REFUSAL OF PLANNING PERMISSION

APPLICATION NO. 2019/0355

Proposal Erection of dwelling.
At Land at South View Farm, High Lane, Ingbirchworth, Sheffield, S36 7GG

PROPOSED GROUND FLOOR PLAN

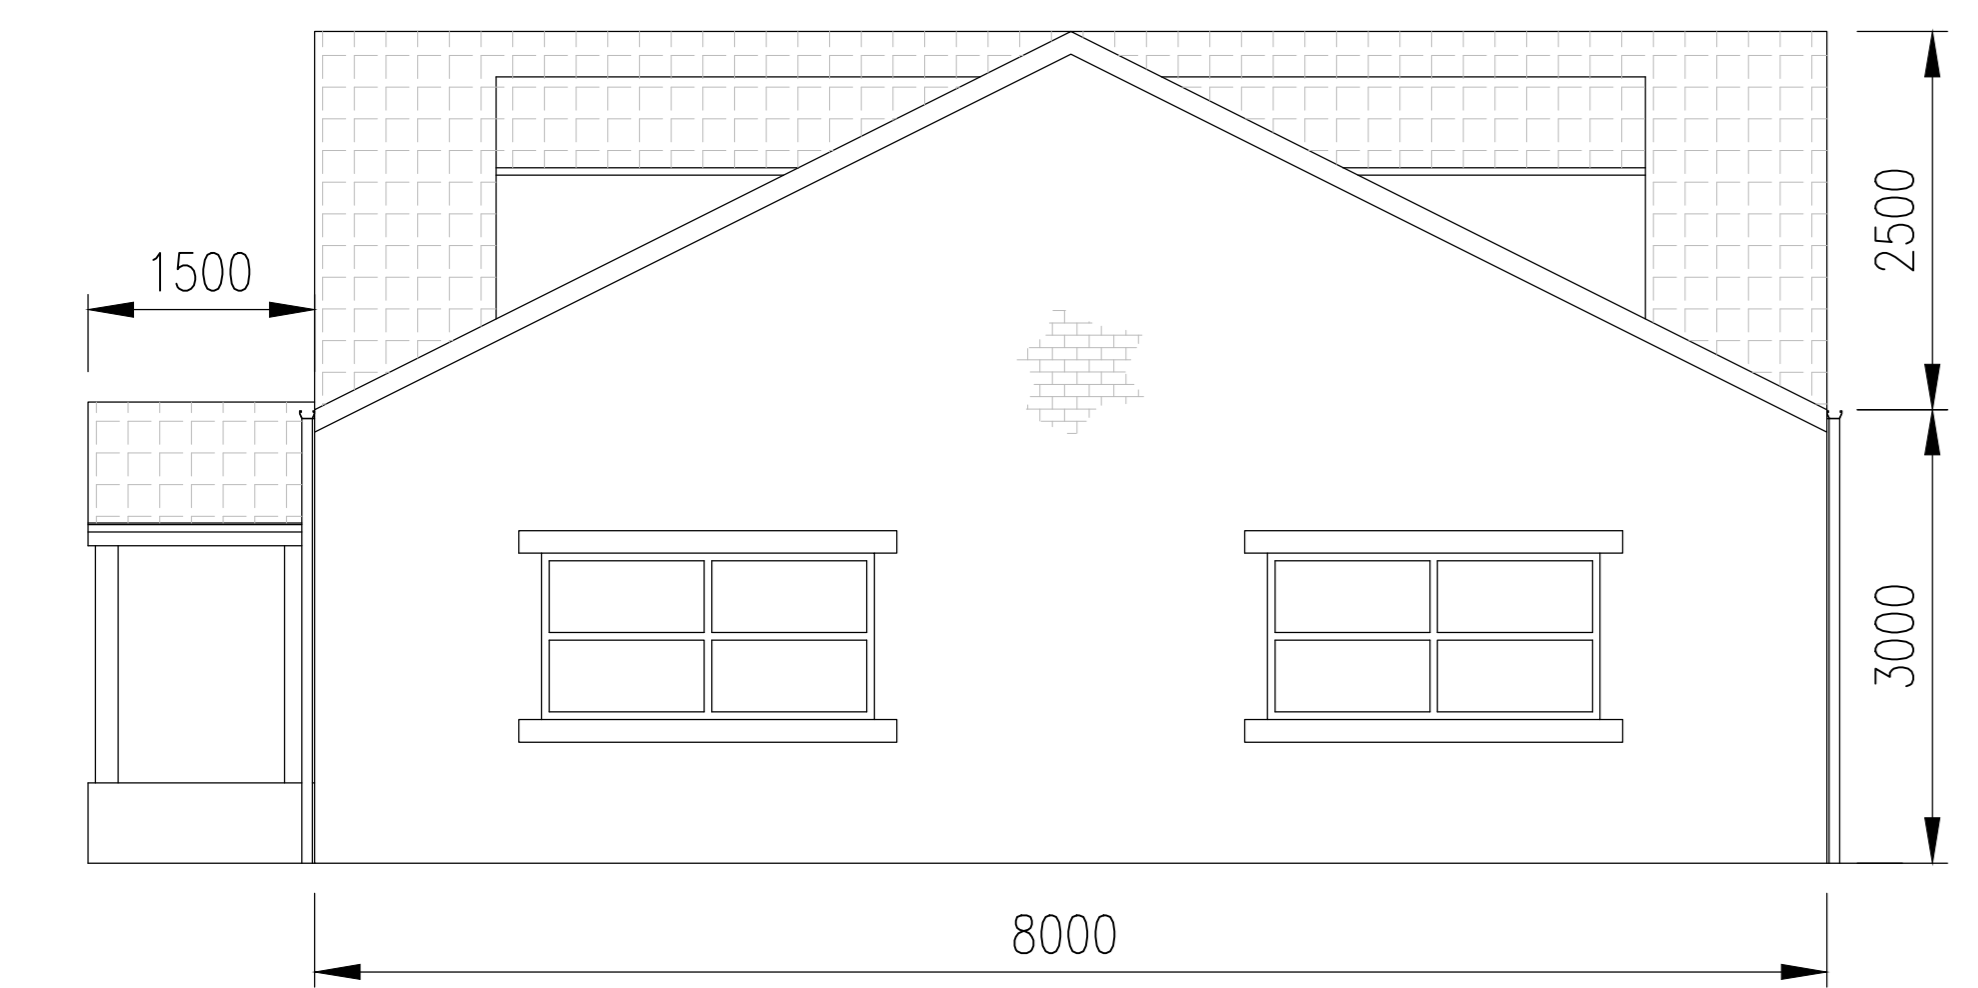
- 2 The site lies within the Green Belt on the approved Barnsley Local Plan, wherein there is a presumption against inappropriate development, unless it is for one of the purposes set out in paragraphs 145 and 146 of the NPPF. In the opinion of the Local Planning Authority, the size and of the proposed dwelling is considered not to be commensurate with the functional needs of a sole agricultural worker contrary to Local Plan Policy GB4.

- 3 The design of the dwelling fails to respect the character of its surroundings and in particular the setting of the Conservation Area and Grade II* Listed Building, Ingfield Barn and is considered to be contrary to Local Plan Policies GB4, HE1 and HE2.
